Our ref: DOC20/880093  
Senders ref: SSI-9364

**Subject: EES comments on Amended application and Response to Submissions for M12 Motorway Project – SSI-9364 between the M7 Motorway at Cecil Hills and The Northern Road at Luddenham**

**Subject: EES comments on Amended application and Response to Submissions for M12 Motorway Project – SSI-9364 between the M7 Motorway at Cecil Hills and The Northern Road at Luddenham**

Figure 1-2 Key features of the project

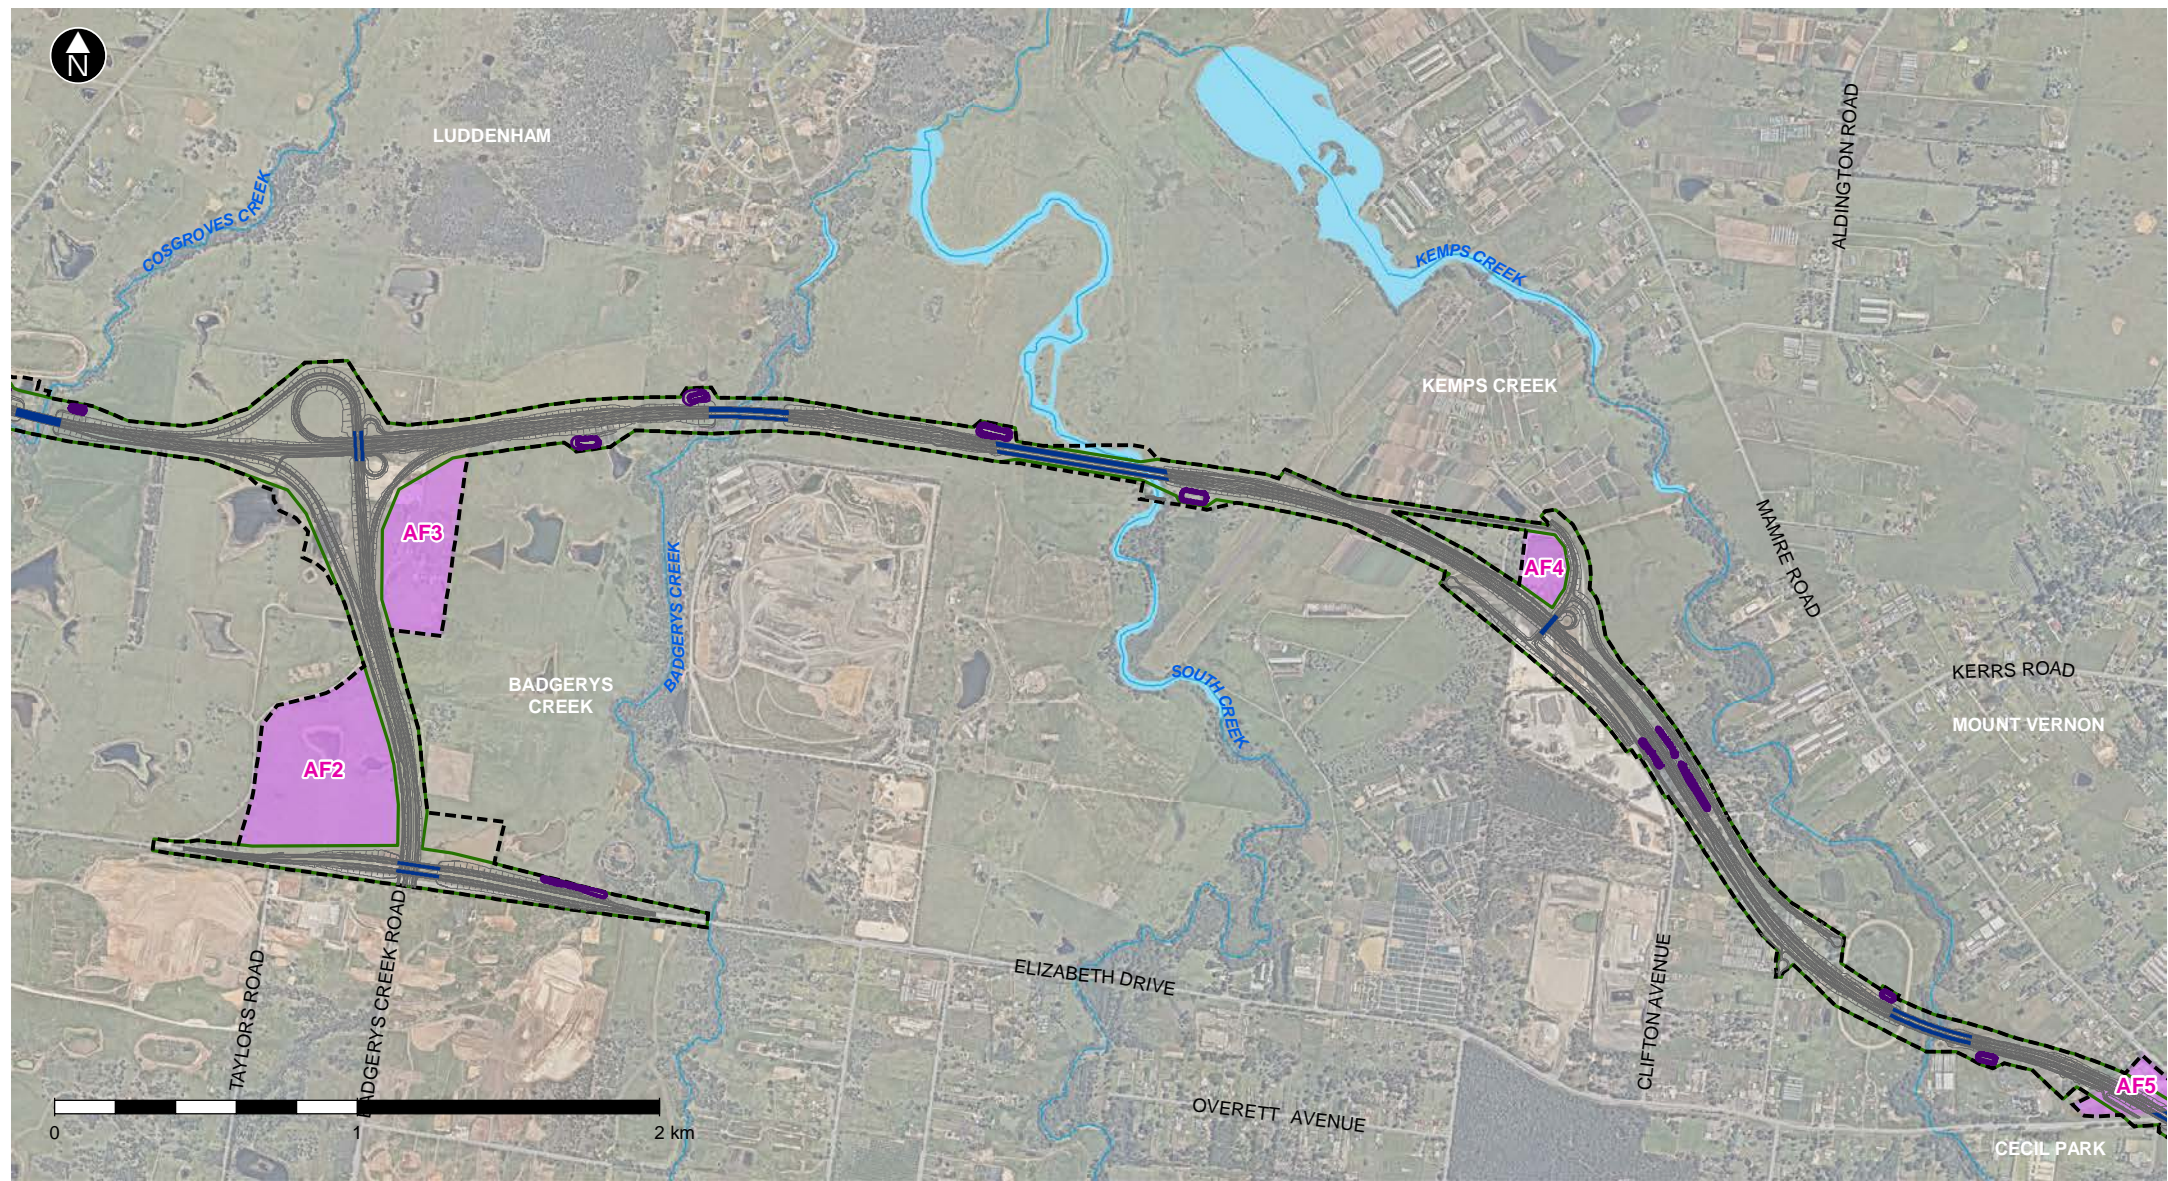
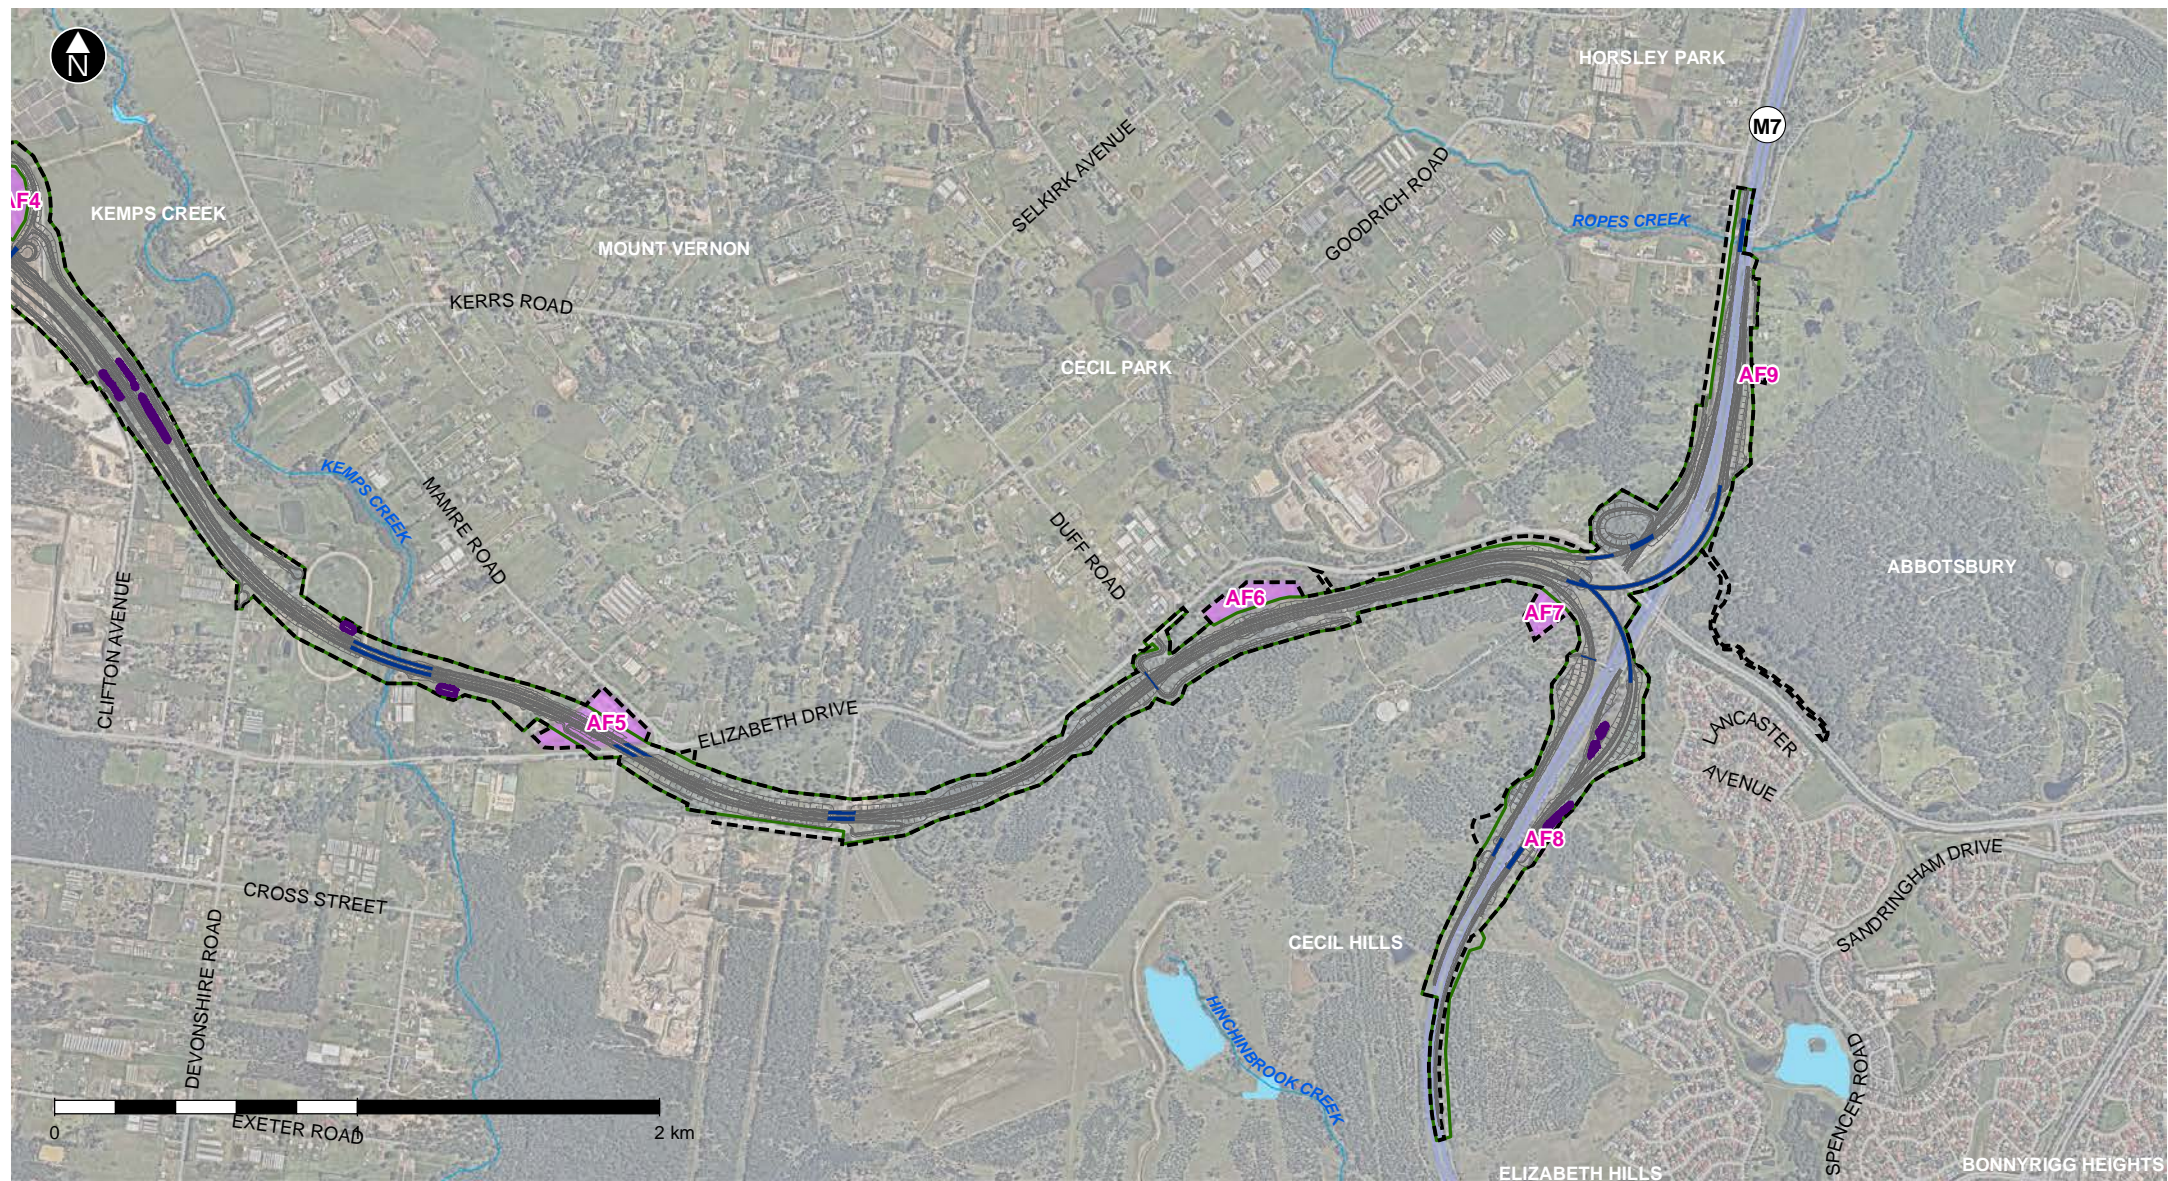
The RTS shows bridge structures are proposed across Ropes Creek, Kemps Creek, South Creek, Badgerys Creek and Cosgroves Creek (see Figures 1-2) and that it is proposed to widen the northbound bridge over Ropes Creek (see Figure 1-2 (page 3 of 3)). It is important the project maintains and/or improves connectivity along the riparian areas, particularly as:

- South Creek is identified in the Western City District Plan as one of the District’s three major watercourses and Planning Priority W13 in the District Plan states, “the design of bridges will respect the local context and environment and support the movement of wildlife”.
- Kemps Creek is a tributary of South Creek and links to Kemps Creek Nature Reserve which is located to the south of the M12 alignment.
- Ropes Creek links into the Western Sydney Regional Park upstream of the proposed widened bridge crossing and downstream it flows through the Wianamatta Regional Park and then into South Creek.

- The bridges are designed to minimise the clearing/disturbance of native vegetation and existing native riparian vegetation is protected.
- The bridge crossings are designed to maintain and/or improve riparian/terrestrial connectivity under the bridge structure to maximise the corridor function.
- The bridge design includes:
  - a. an elevated structure
  - b. span the full width of the riparian corridor and/or remnant native vegetation which-ever is the widest to avoid or reduce the need to clear and/or disturb remnant native vegetation along the creeks
  - c. maximises light and moisture penetration under the structure to encourage native plant growth, for example the bridges could include a grate in the structure (see photos below)
  - d. a gap is provided between the proposed twin bridge crossings to assist in allowing light and moisture penetration under the two structures.
